# DRB CASE ACTION LOG

DRB Application No.: 05 01474 Project # 1002051  
 Project Name: Ohamsa Pledge  
 Agent: Sierra White Phone No.: 858-3100

**RE: Chamisa Ridge, Unit 2/final plat**

**DRB CASE NO/PROJECT NO: 1002051**

Plat of
Chamisa Ridge, Unit 2
 Albuquerque, Bernalillo County, New Mexico
 April 2005

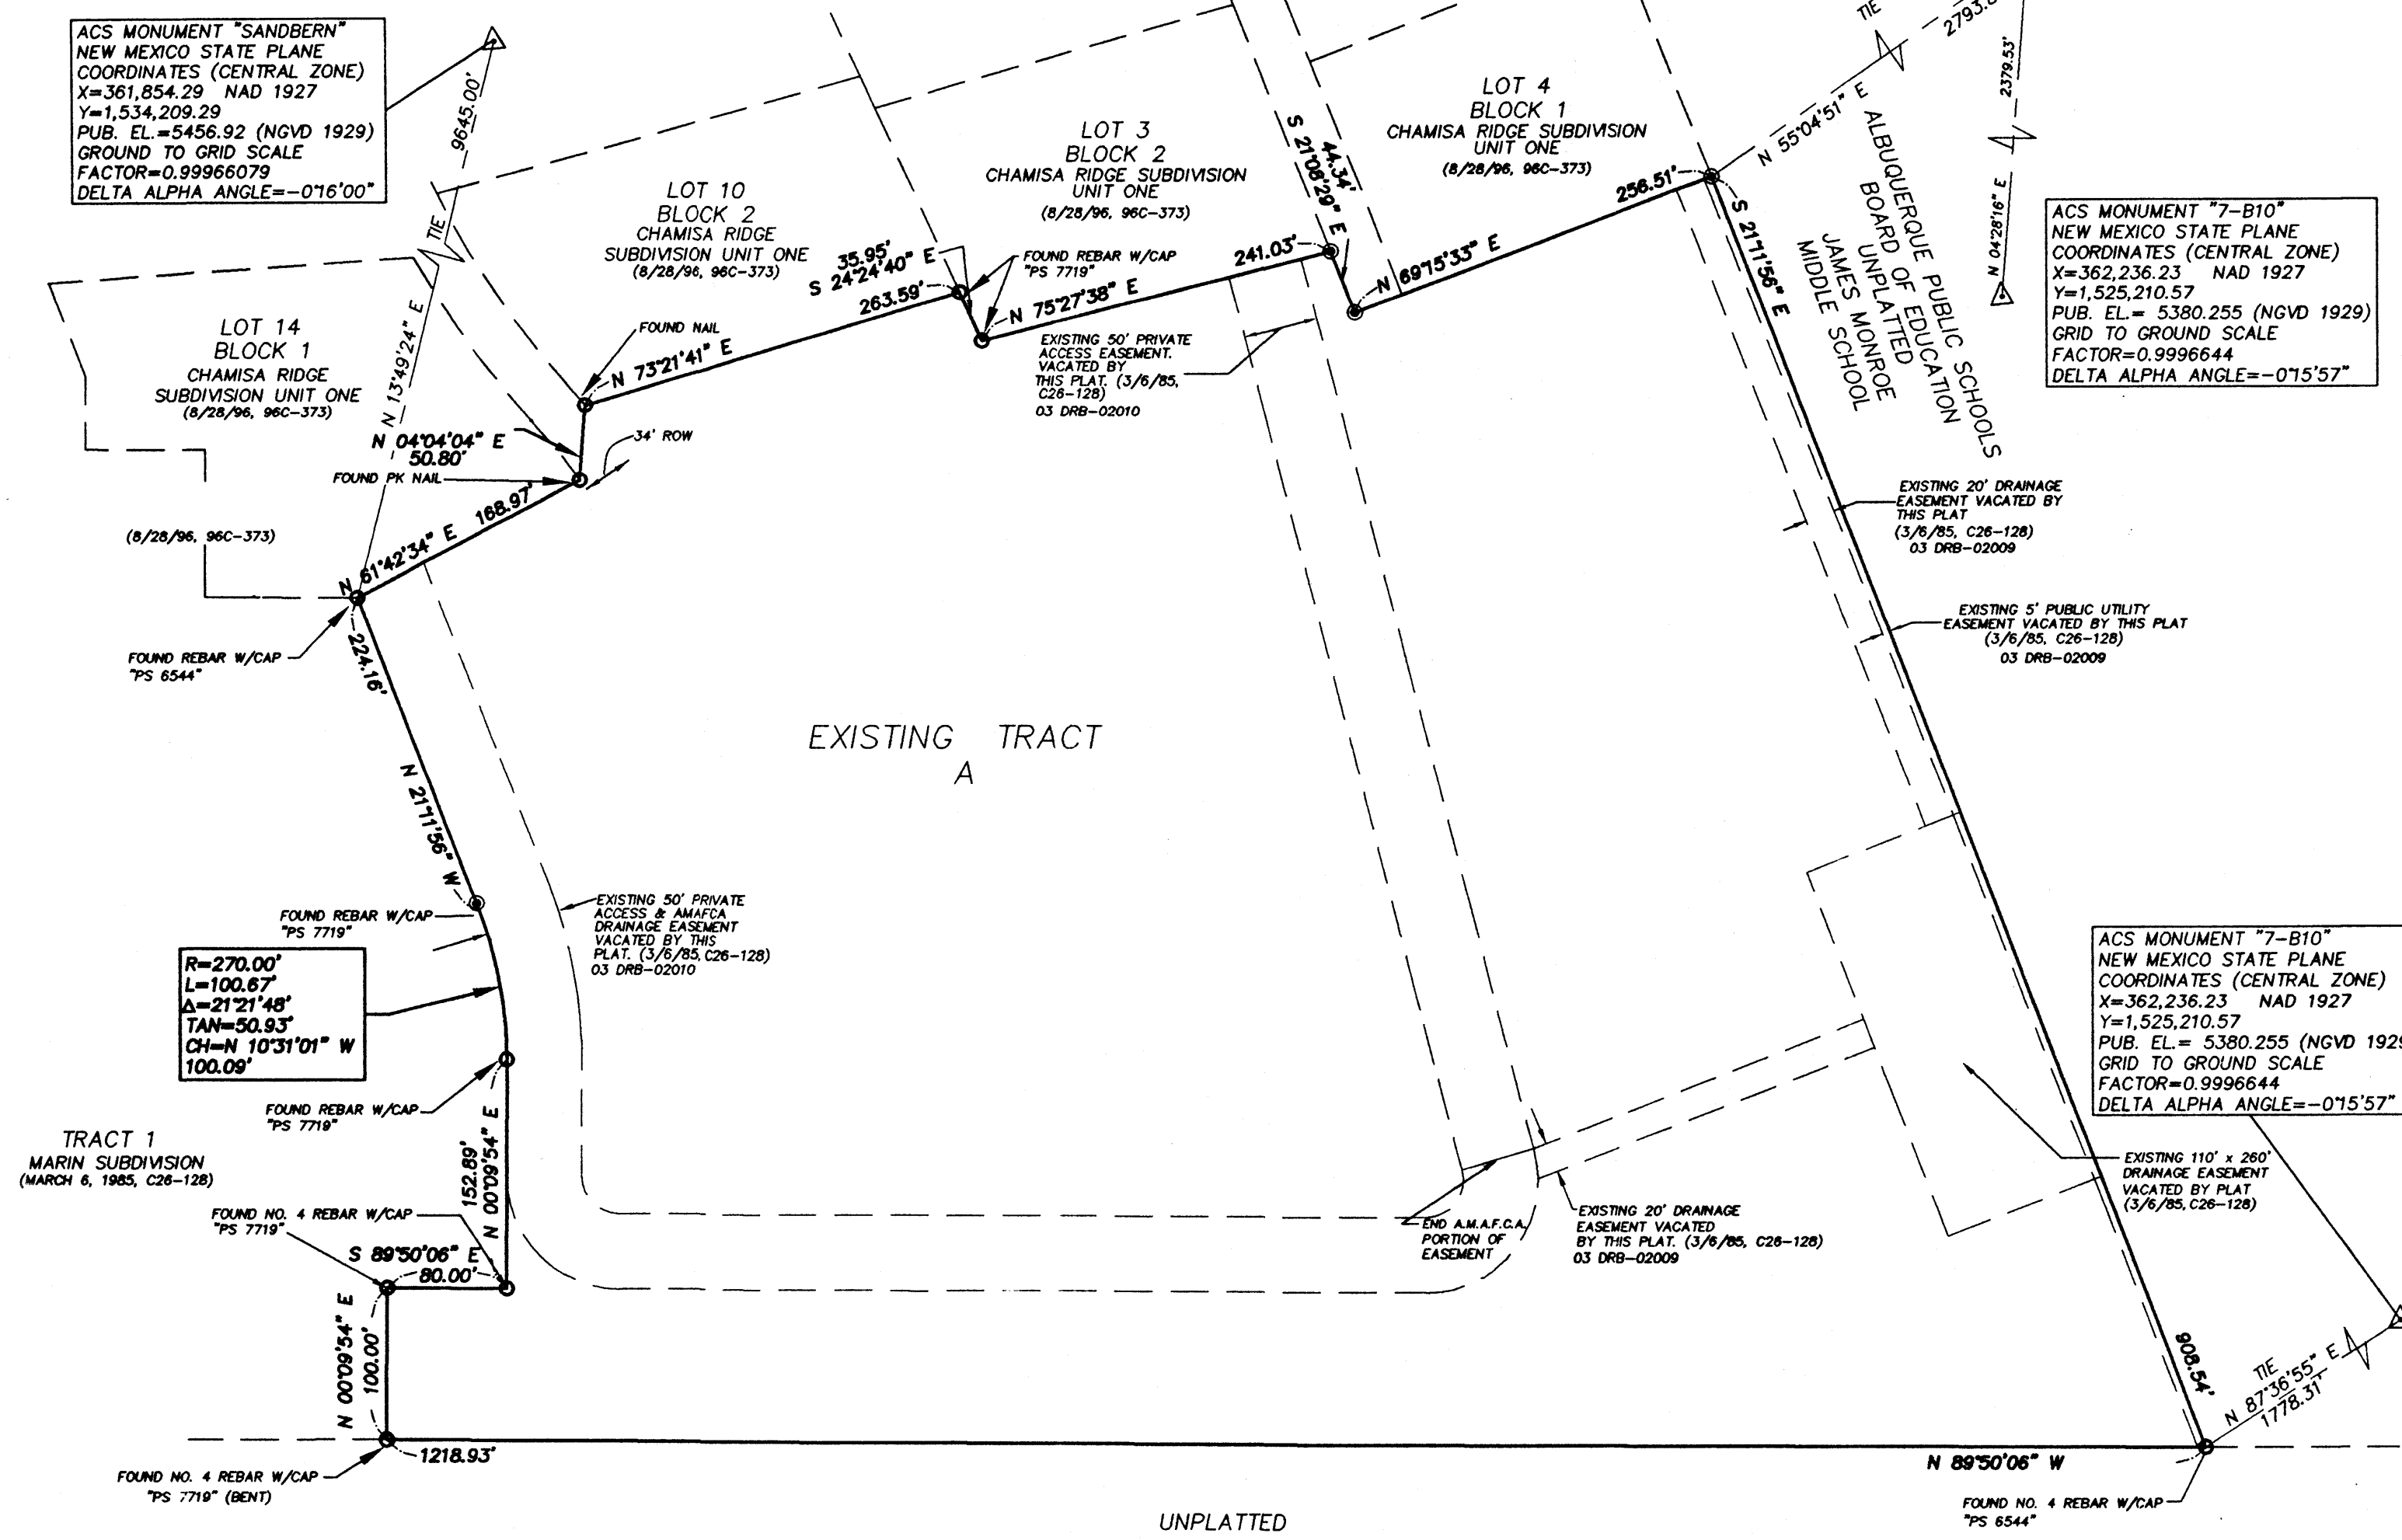
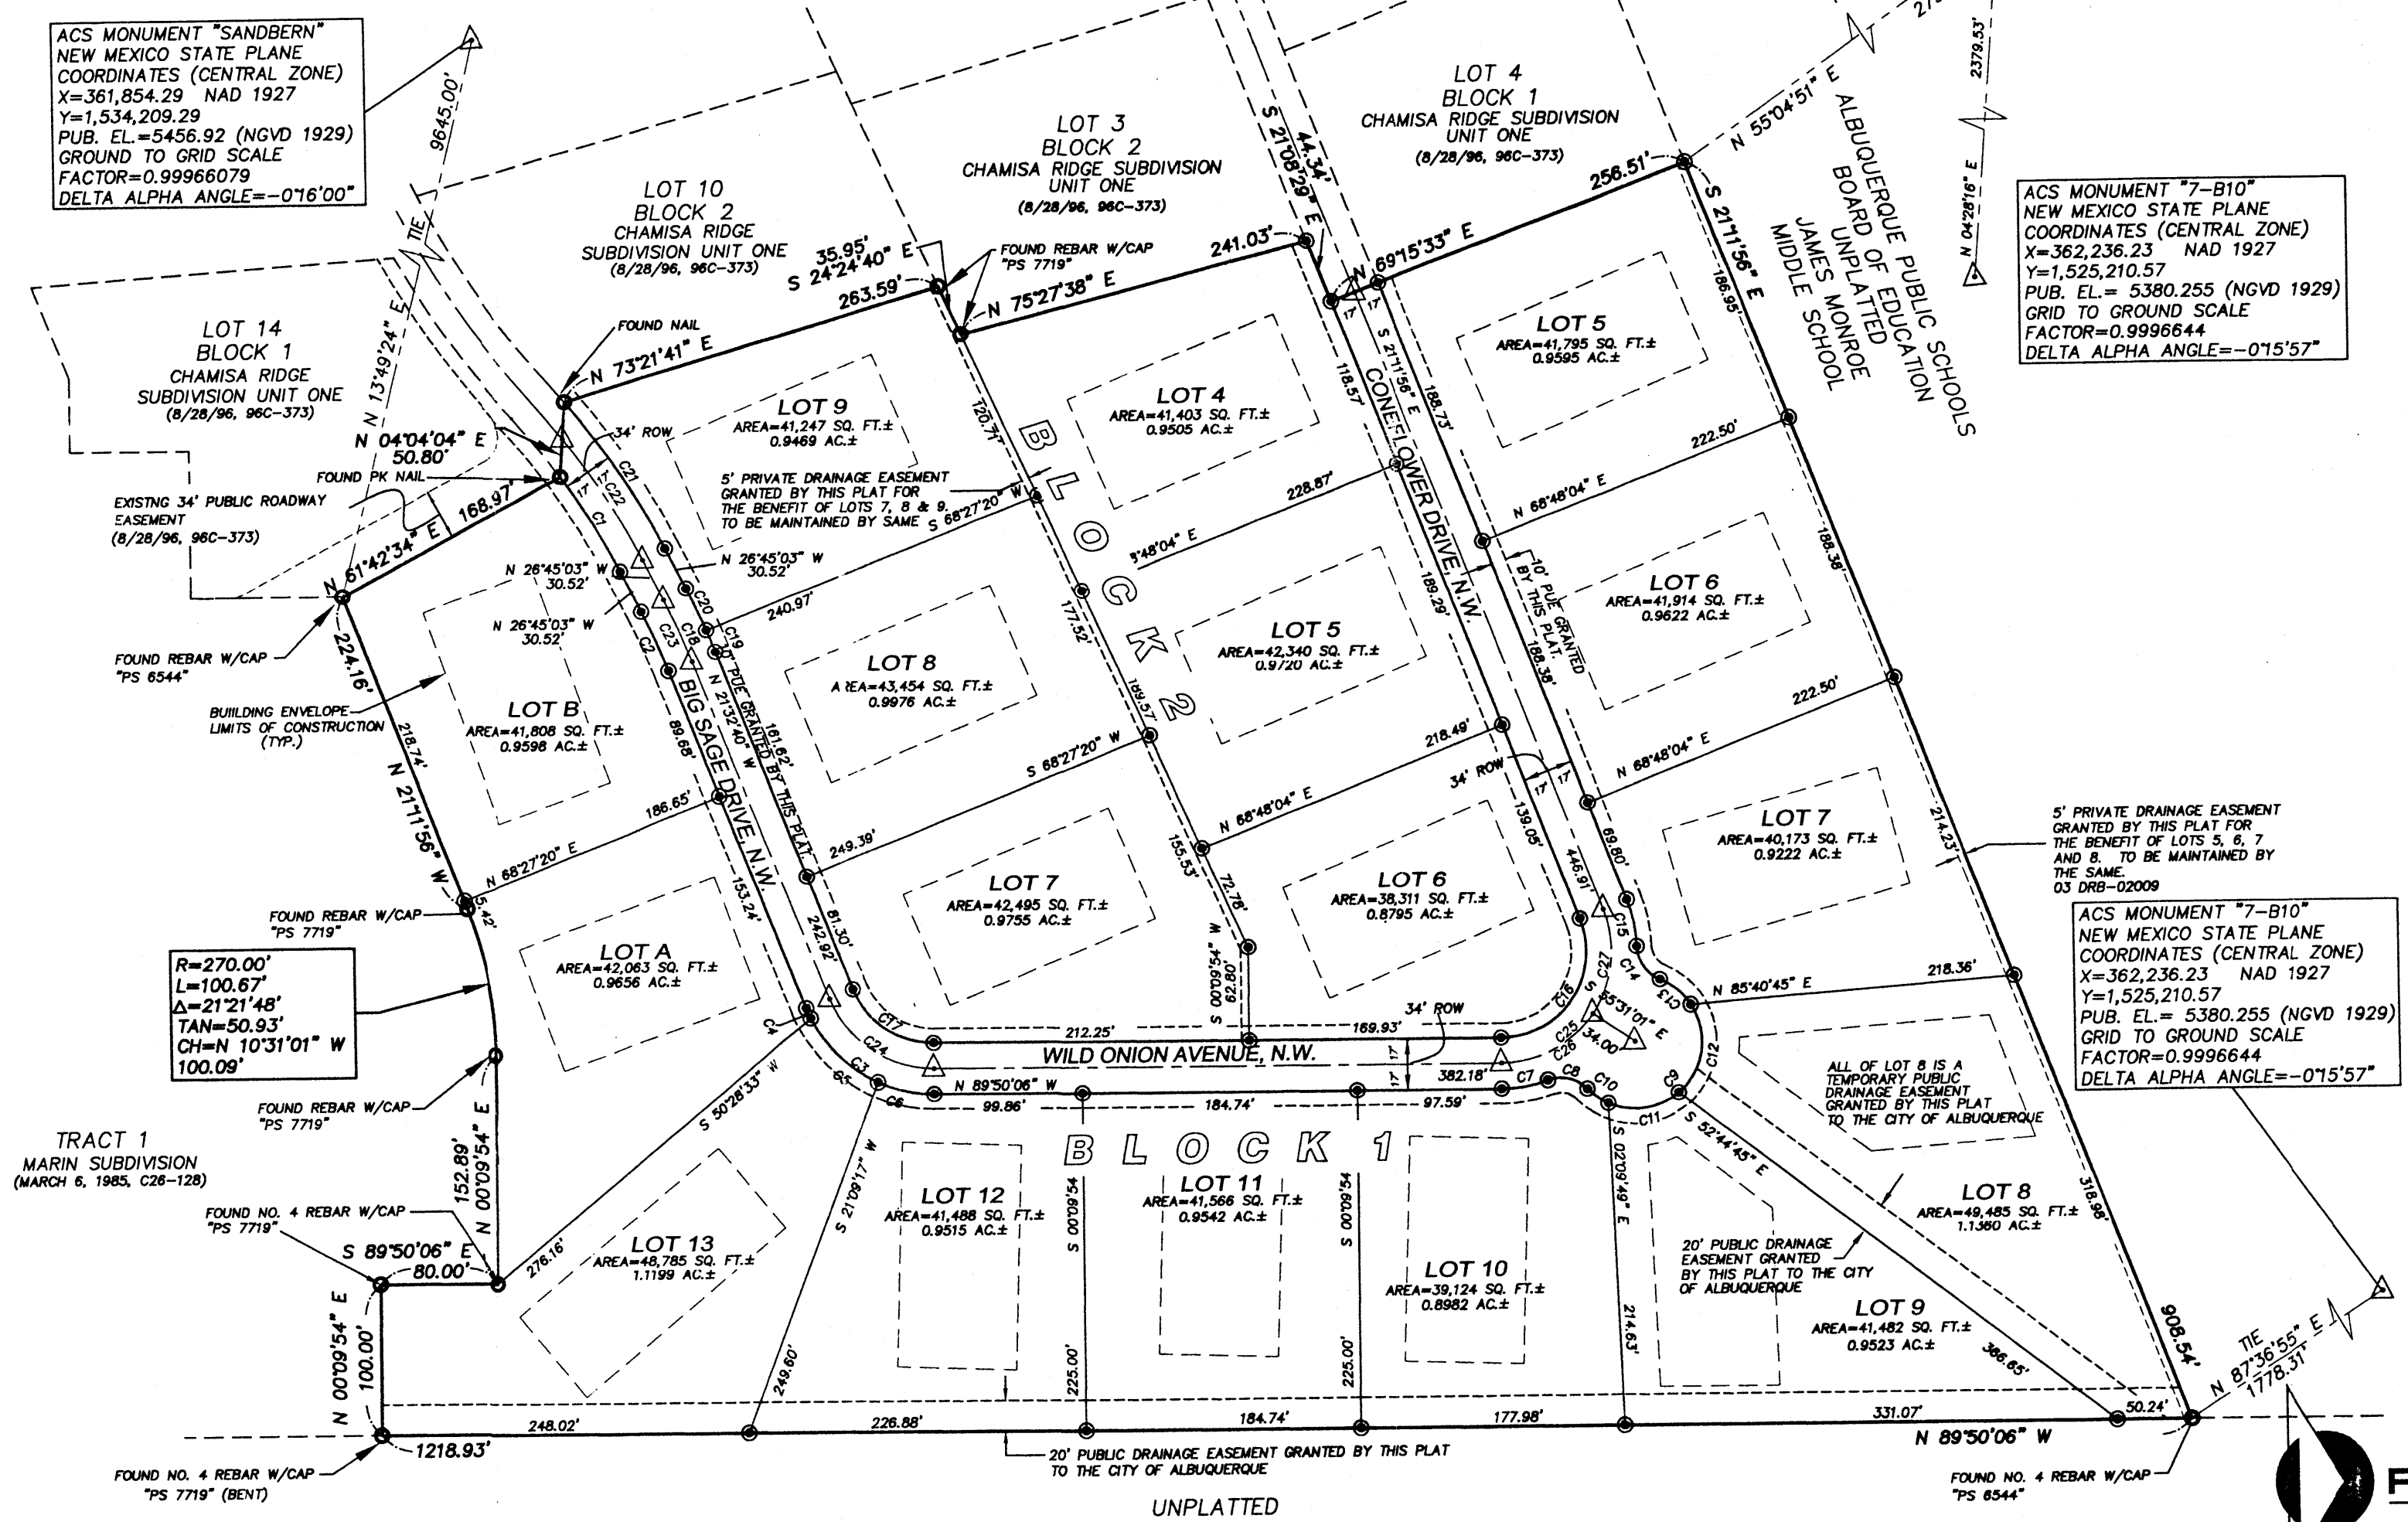
CITY ENGINEER / AMAFCA: AMAFCA sig  
 NMUE sig  
 call put esmt MGB  
 Pub. ded. to COA

AMAFCA must sign plat.  
Public drainage easements should be dedicated to City.  
Private drainage easements should state maintenance and beneficiary responsibilities.
